CITY OF ALBUQUERQUE

May 11, 2011

**Re: The Boulders Phase 1 Subdivision Drainage Report and Grading and
Drainage Plan**

Engineer's Stamp date 5-6-11 (B11/D001B)

THE BOULDERS PHASE 1 GRADING AND DRAINAGE PLAN	DRAWN BY DY
		DATE 05-06-11
	TIERRA WEST, LLC 5571 MIDWAY PARK PLACE NE ALBUQUERQUE, NM 87109 (505)856-3100 tierrawestllc.com	2011005-SH01-02- GRE-PH1
		SHEET # 7 JUN 14 2012

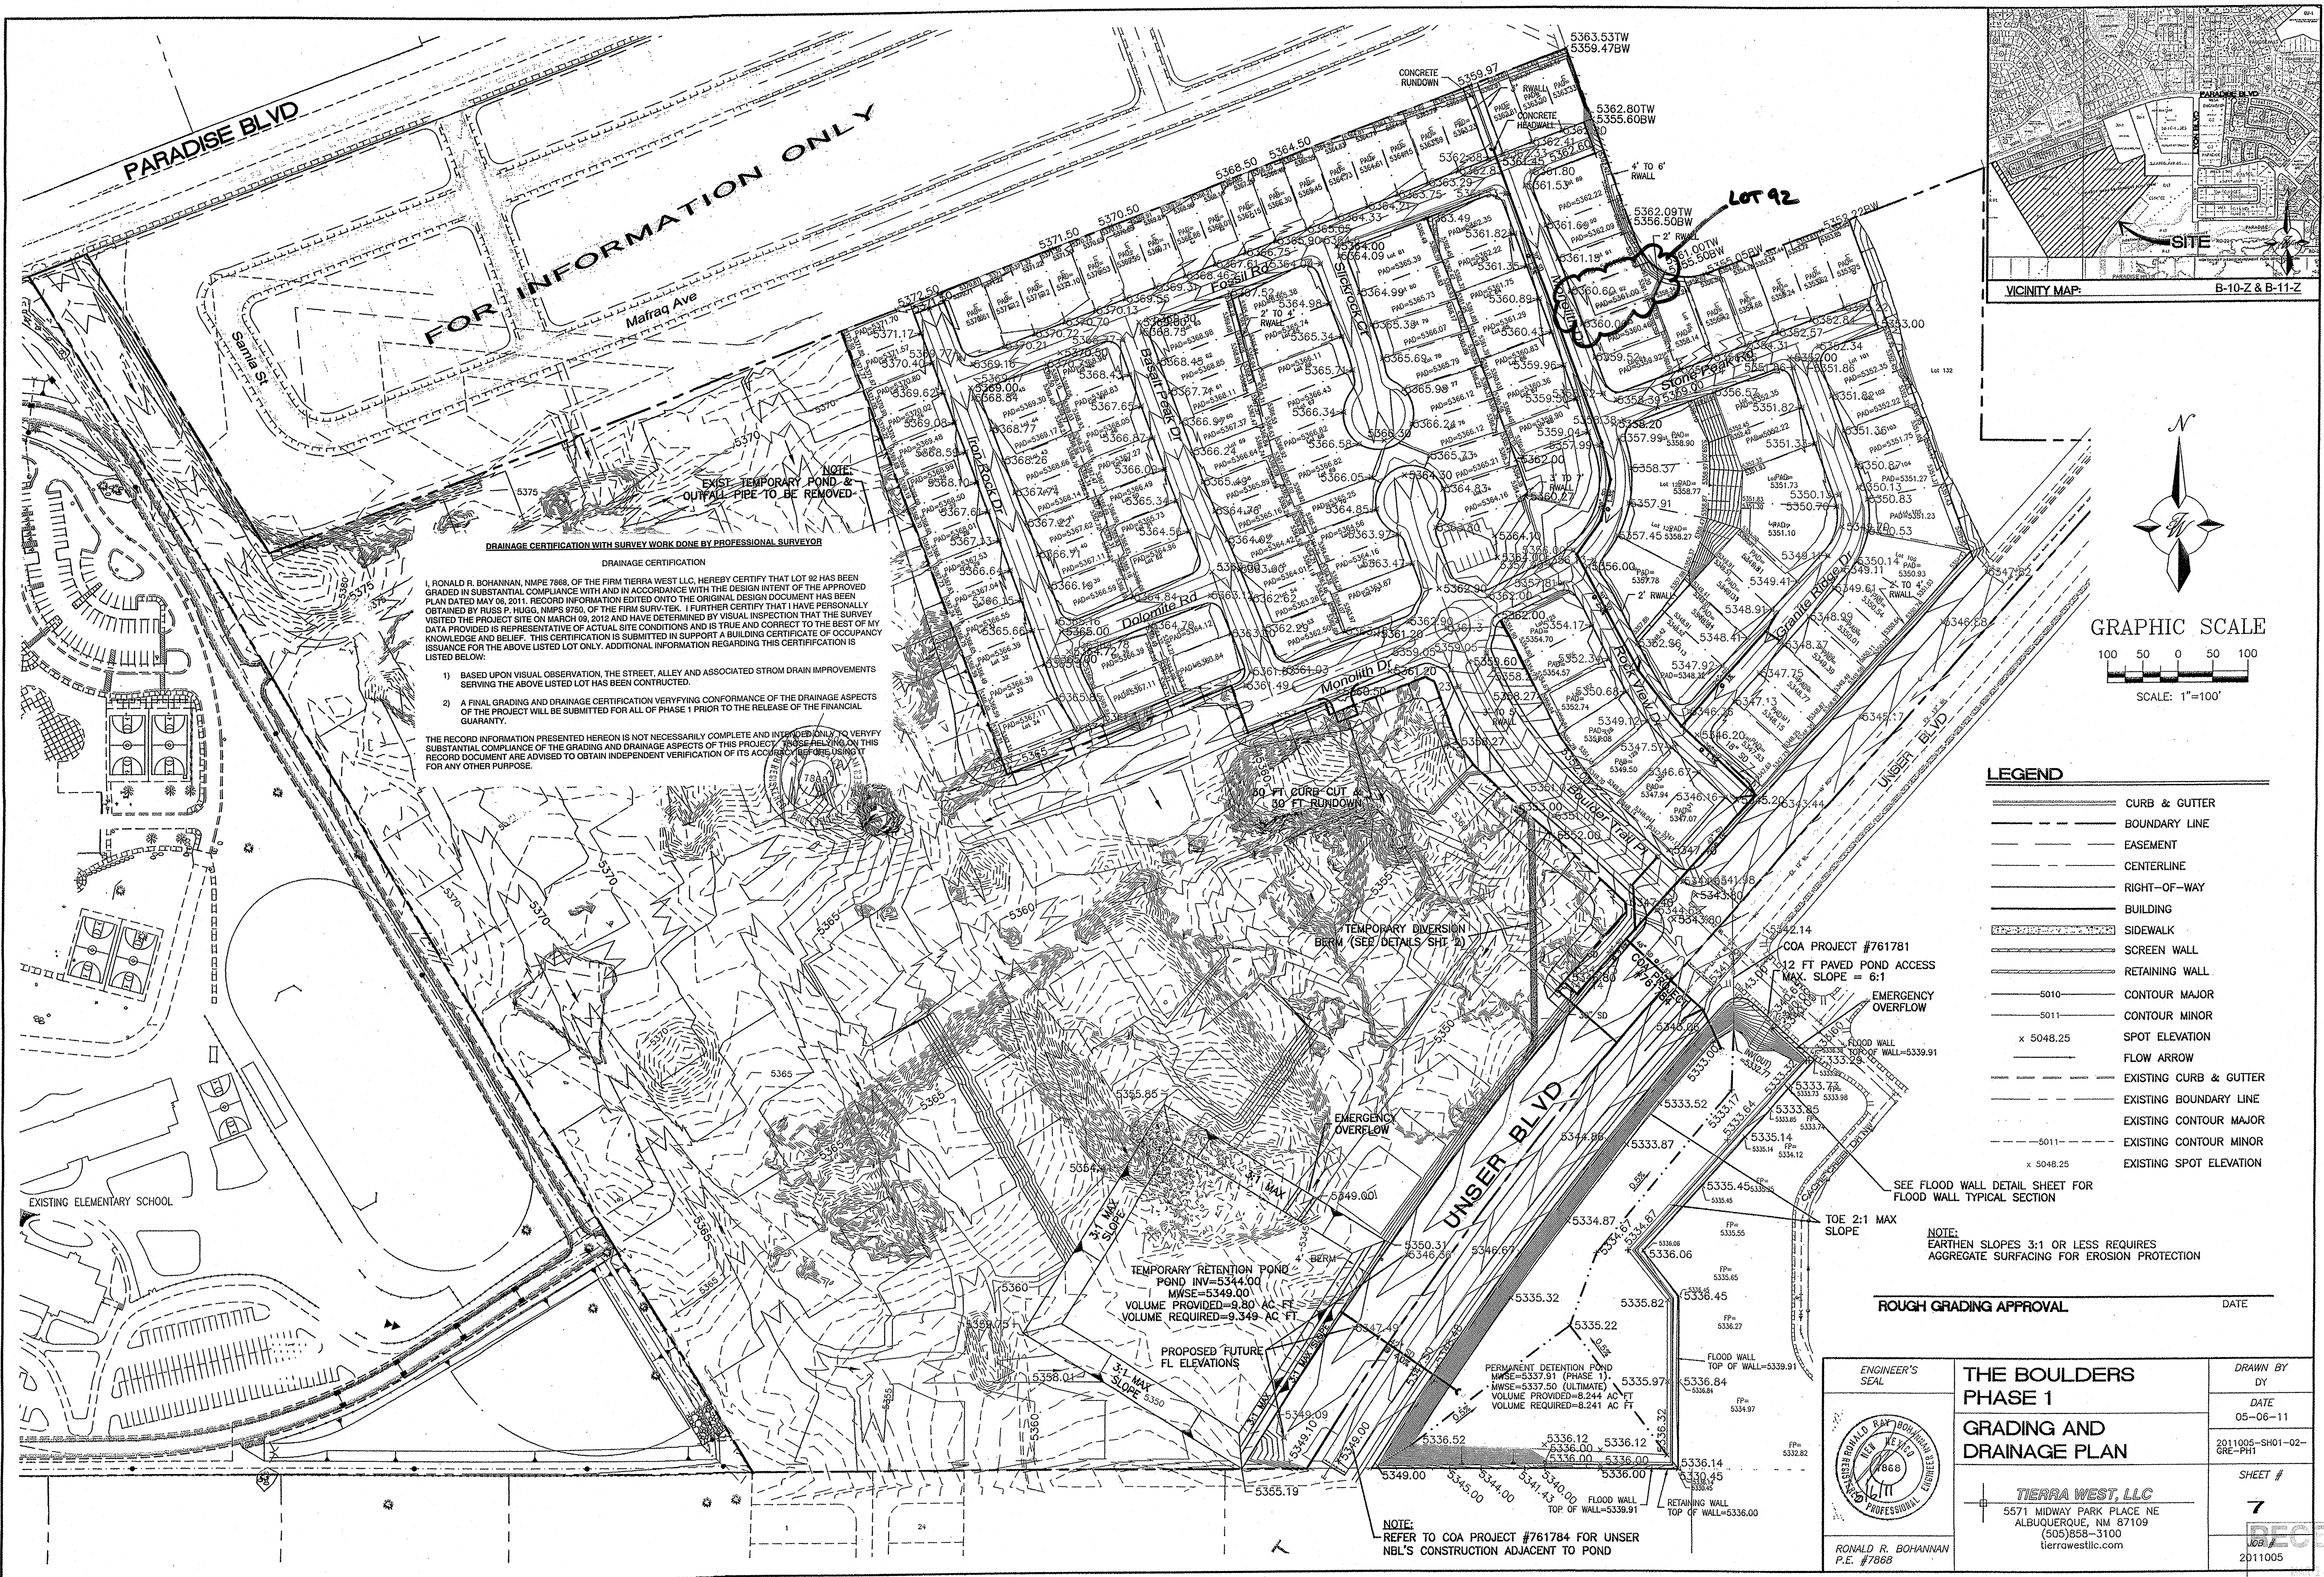
An Agreement and Covenant is required for the Temporary Retention Pond west of Unser Blvd as a condition for Work Order approval.
